COUNTY COUNCIL'S RESPONSE TO CONSULTATION ON THE FOLLOWING DEVELOPMENT PROPOSAL

Application No: 19/01746/OUT-2

Proposal: Outline planning permission (with all matters reserved excluding access) for up to 10,200sqm of B1 development (B1a and/or B1b and/or B1c); access and associated landscaping and infrastructure works

Location: Land Adj To Promised Land Farm, Wendlebury Road, Chesterton

## PROPOSED SURFACING PLAN

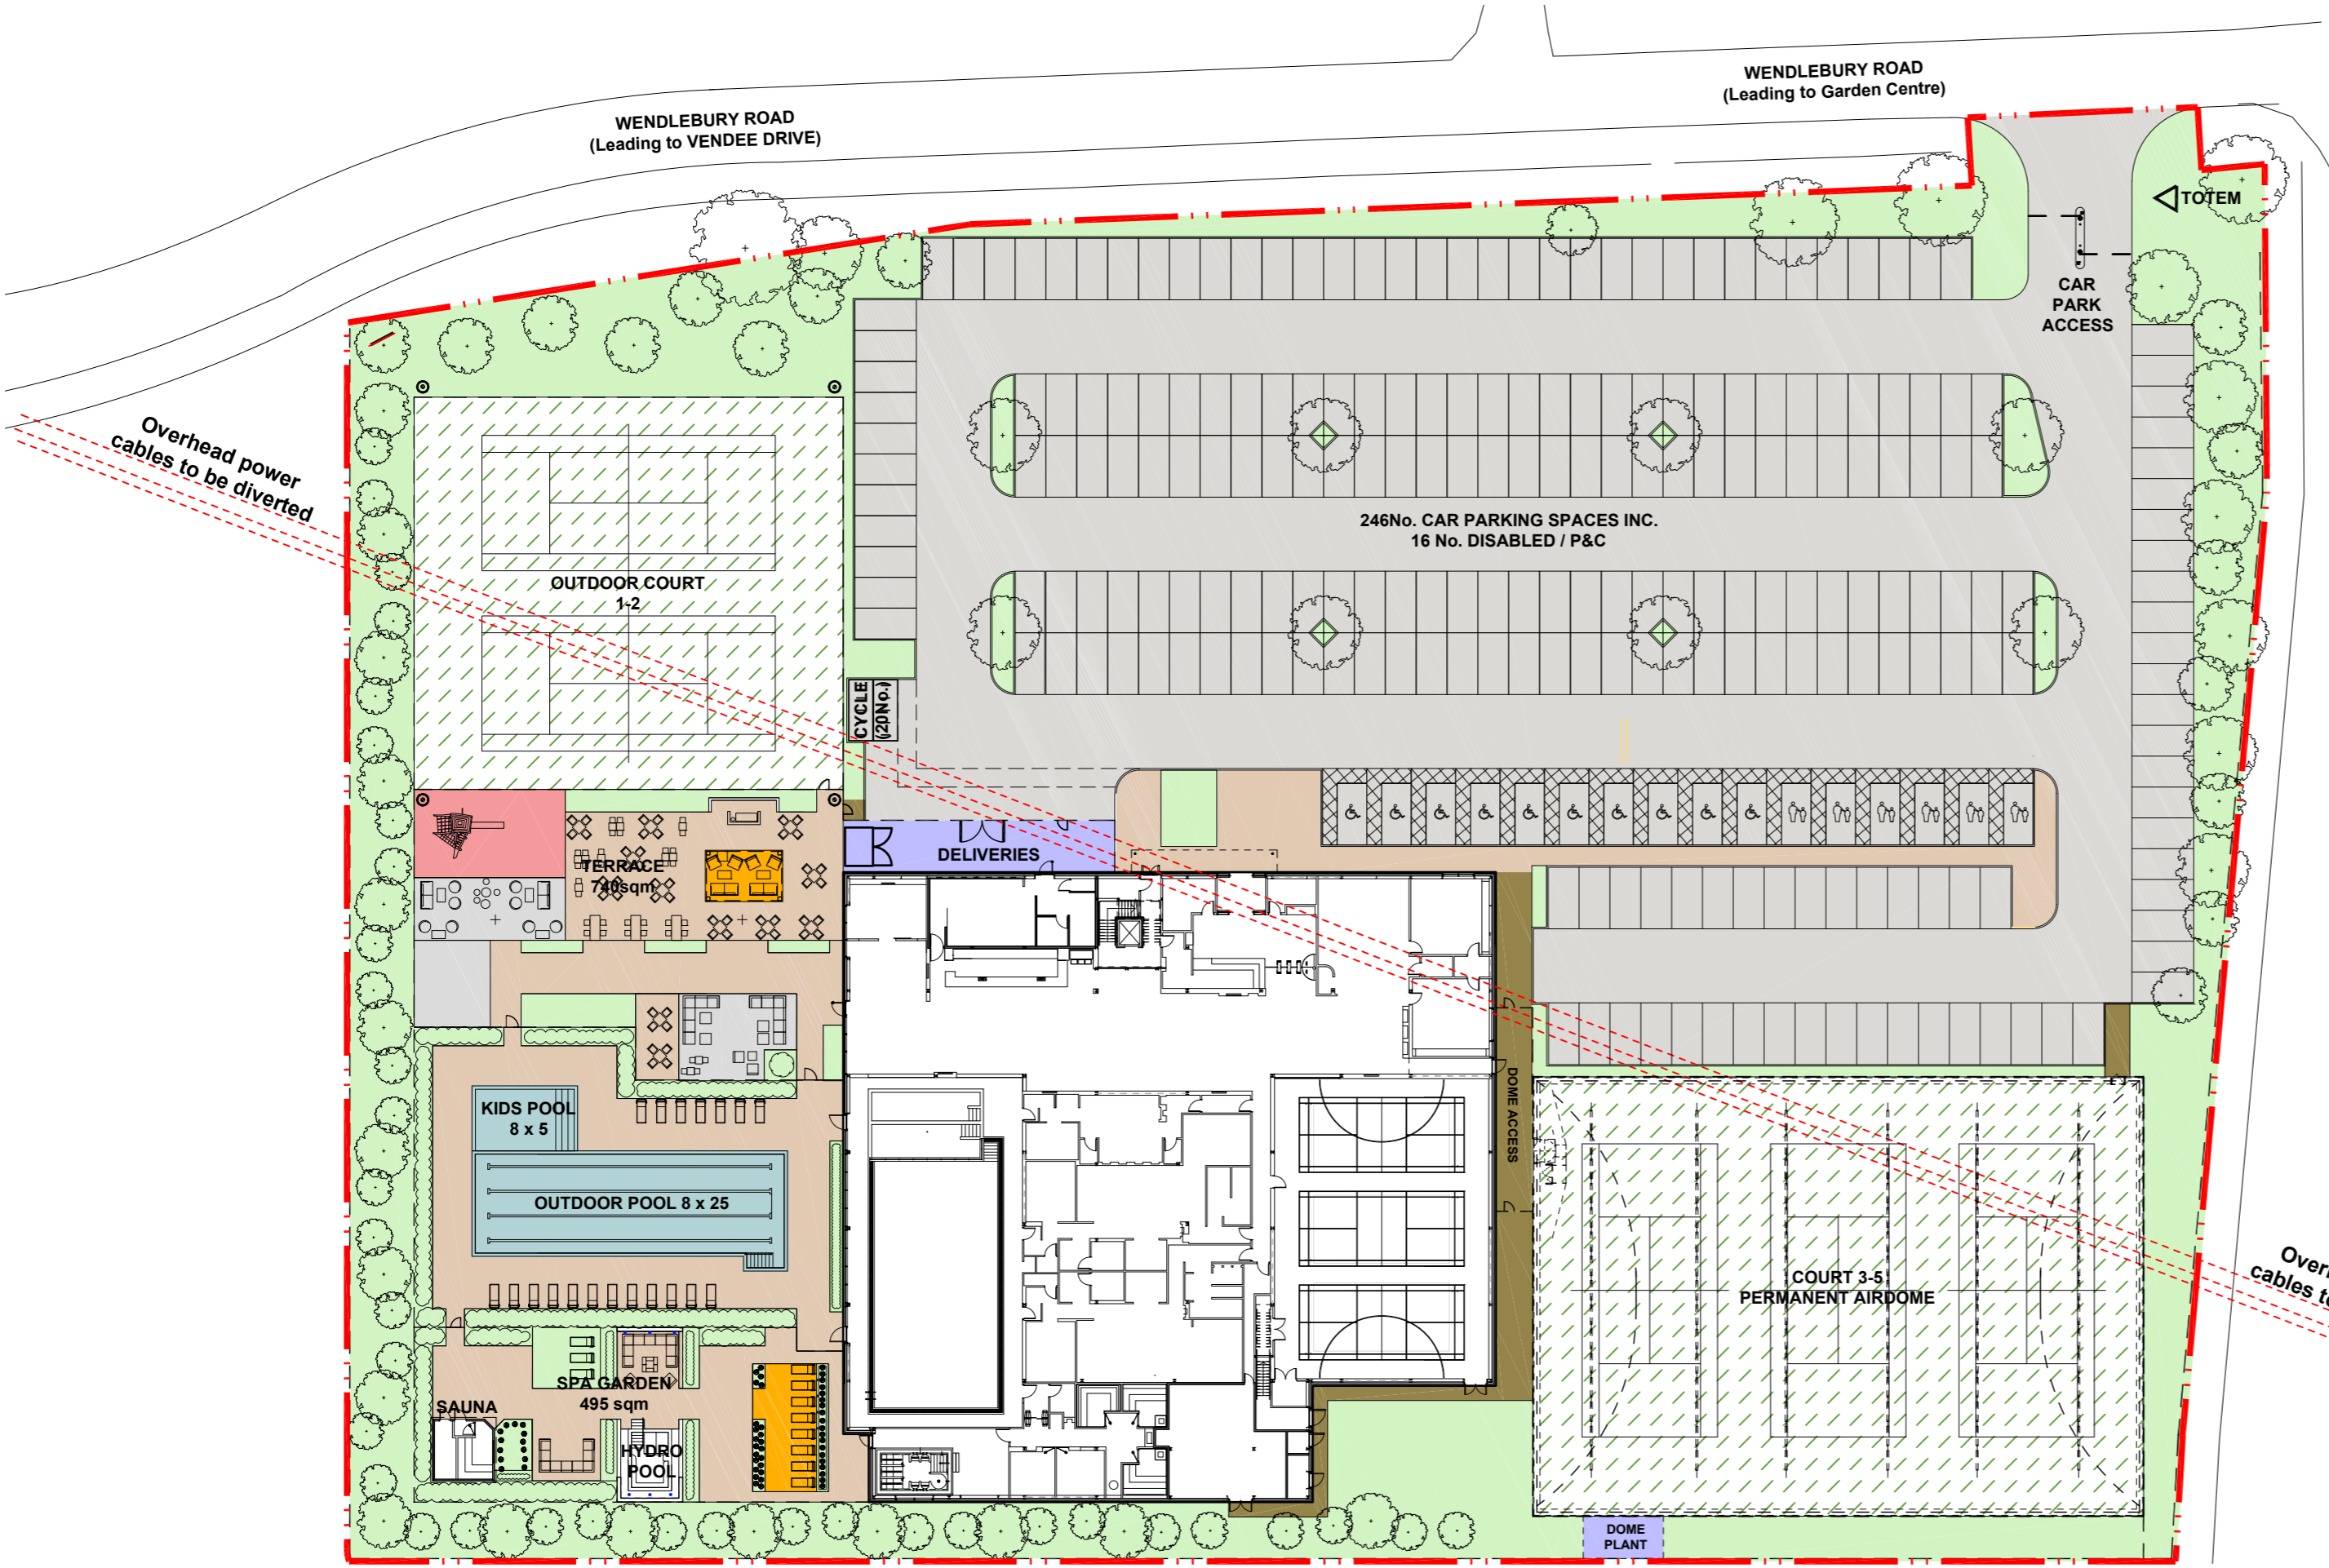
The proposed site plans do not indicate provision of electric vehicle charging points for any of the parking spaces. In line with the revised NPPF, para 110 (e) requires that developments should be designed to enable charging of plug-in and other ultra-low emission vehicles in safe, accessible and convenient locations.

Cycle Parking – The site layout plan only shows the location of cycle parking within the Health and Racquet Club but does not indicate how many these shall be and/or whether they shall be covered. From the indicative site plan (Drwg No. 18022-SK-024 Rev D) there are only 5 sheffield stands which can accommodate not more than 10 bicycles. I see this is an under-provision that does not encourage use cycling as a mode of transport. *Table 25* in the TA makes reference to cycle parking standards but fails to include standards for D2 land uses. According to these, a cycle stand is required per 20sqm of floorspace. The TA has not indicated the massing (in terms of floorspace) that the Health and Racquets Club shall take. However, the applicant has agreed to make provision for 30 cycle parking facility which must be covered. I believe there is sufficient space within the layout to accommodate the extra number of stands.
